**KIRKLEES METROPOLITAN COUNCIL
INVESTMENT & REGENERATION SERVICE**

DELEGATED DECISION TO DETERMINE PLANNING APPLICATIONS

Reference No:	2021/62/93442/W
Site Address:	Coffee Novo, 50, New Street, Huddersfield, HD1 2BW
Description:	Change of use of first and second floor to form 3 apartments (Within a Conservation Area)
Recommending Officer:	Stuart Howden

Officer Report

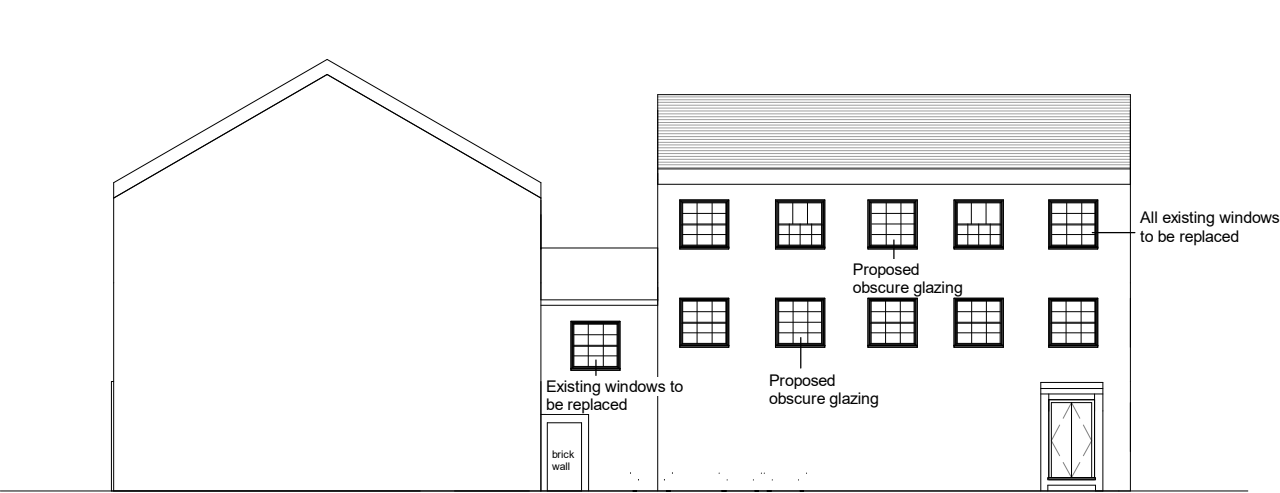
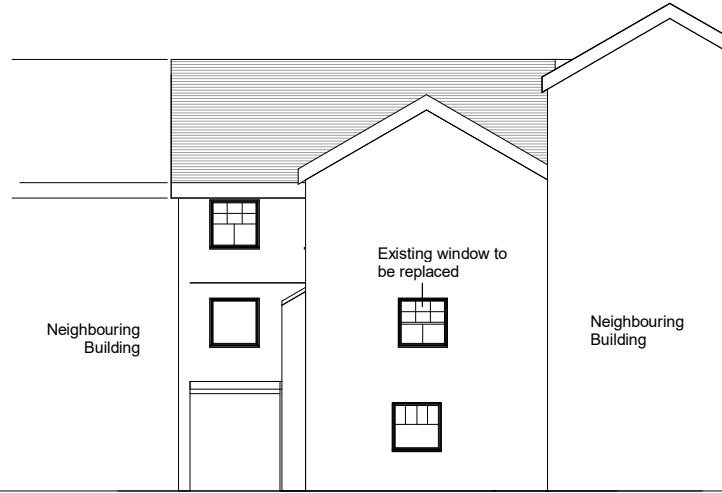
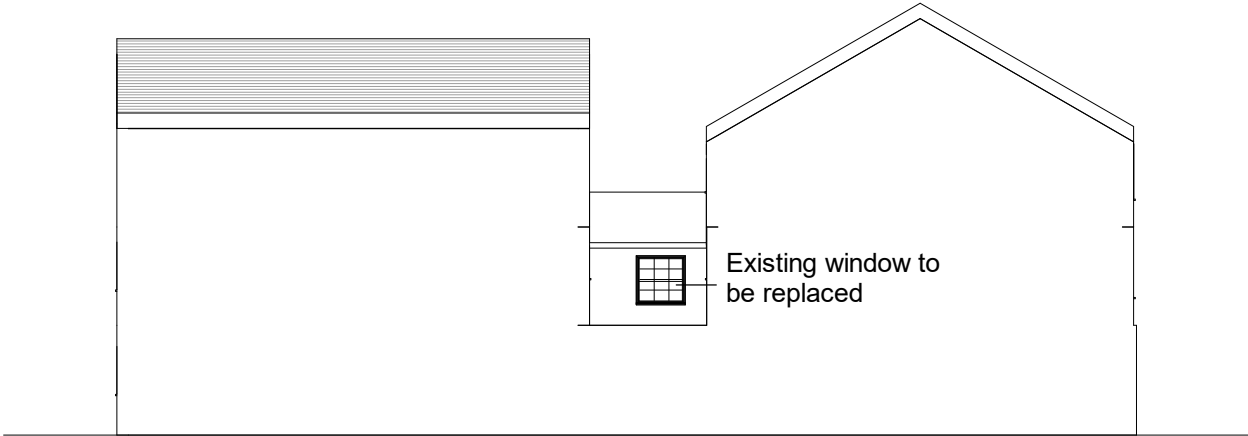
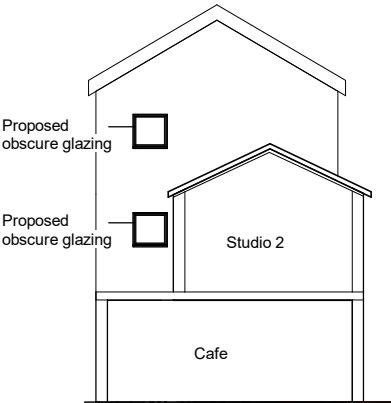
The only external alterations proposed relate to replacement windows/openings and two new openings on the eastern elevation.

Throughout the processing of this application, Officers have raised a number of concerns with the details provided in relation to the external works, for example due to plans not accurately reflecting site circumstances, due to a lack of clarity with what is proposed and concerns with the overall detailing.

Given the above, it is considered that a suitably worded condition is required in relation to openings to the building and should imposed It is considered that such a condition would prevent detrimental harm to the visual amenities of the locality as well as prevent harm to the significance of the Huddersfield Town Centre Conservation Area and the significance of the nearby Grade II listed buildings and their setting. It is therefore considered that the proposal would comply with Local Plan Policies LP24 and LP35 and Chapters 12 and 16 of the National Planning Policy Framework. As listed building consent is required for the replacement windows, the requisite conditions will be imposed on the allied application for listed building consent, not this planning permission.

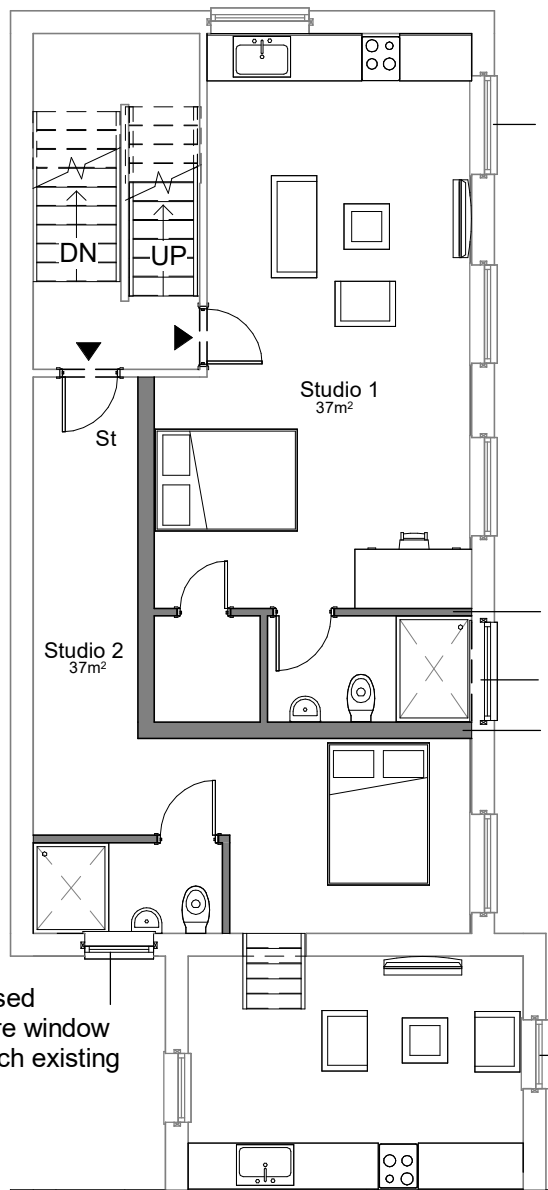
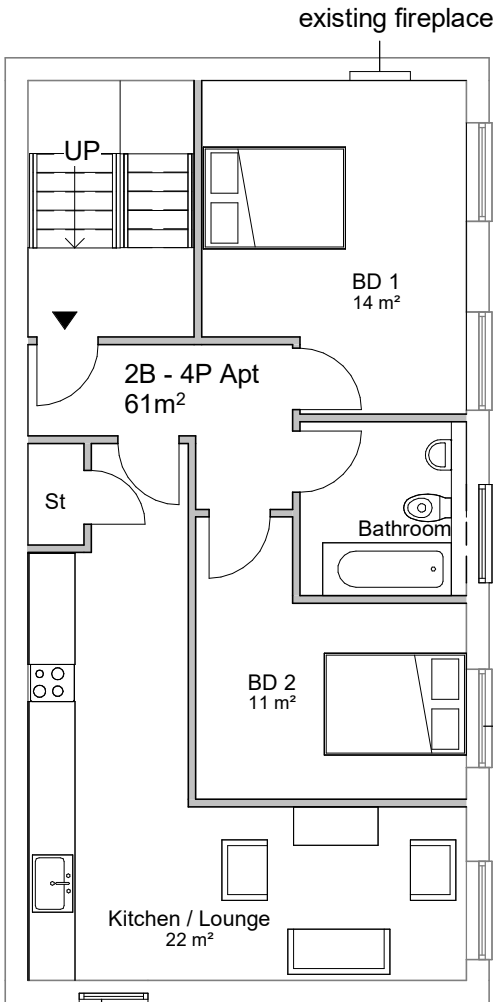
Of note, the latest set of plans display the full replacement of the existing windows of the building at No's. 1-2 Union Bank Yard. No justification has been provided for this and KC Conservation have raised significant concerns with this noting that they are unable to support the replacement of the historic windows on the north and west elevations as there is no evidence that the existing are beyond repair and in need of replacement. KC Conservation have also stated that these historic windows should be retained and restored, with

secondary glazing fitted where necessary. Officers concur with KC Conservation and this information is required so as to preserve the significance of the listed building and the conservation area.

Window Details

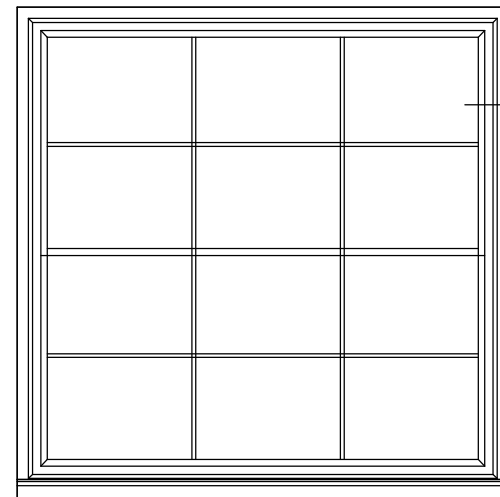
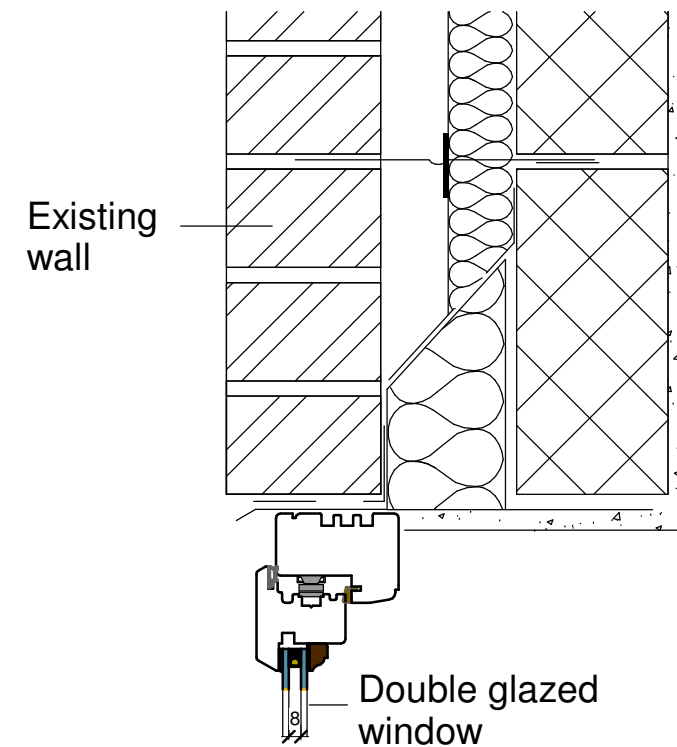
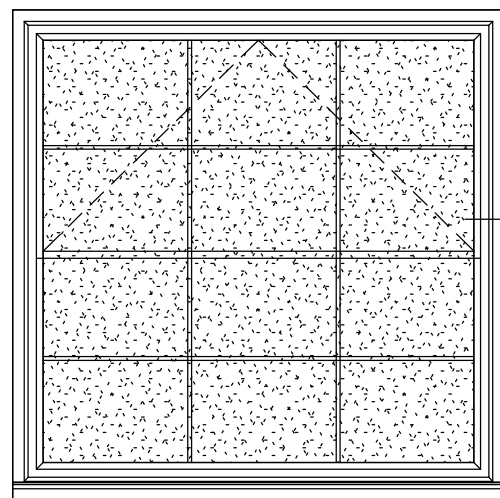
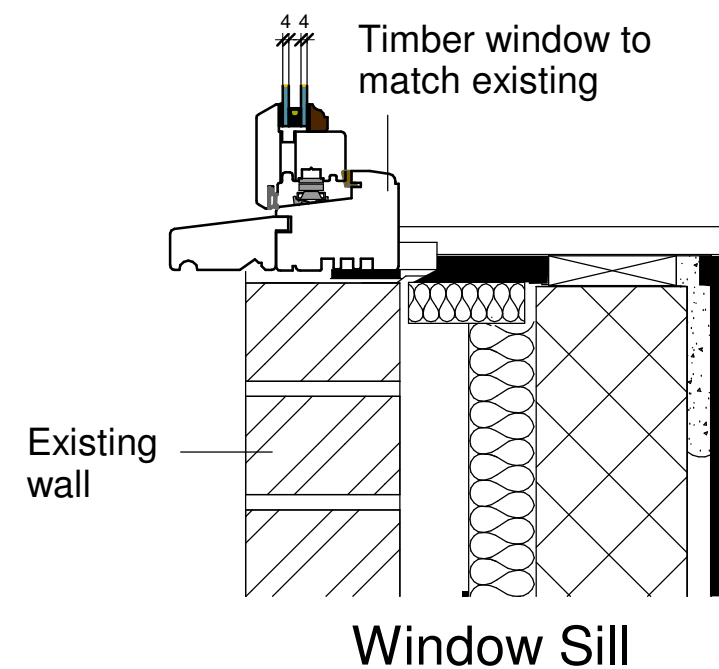
KC Conservation note that if replacement windows are accepted, these would need to replicate the historic details and details of this would also be required. It is noted that a window plan has displayed top hung windows, whilst the historic windows are traditional sash windows. There are also no details whether such replacement windows are single glazed or double glazed. In addition, the former loading door on the link building may need to be treated differently to the other windows. The cill of the proposed windows appears to be going too far out from the reveal too. Details of the proposed obscured glass have also not been provided, and Officers hold the view that a plain etched glass is more appropriate than patterned glass.

Therefore, if replacement windows are considered acceptable, Officers would also require further details of these, as well as new windows, so as to preserve the significance of the listed building and conservation area.
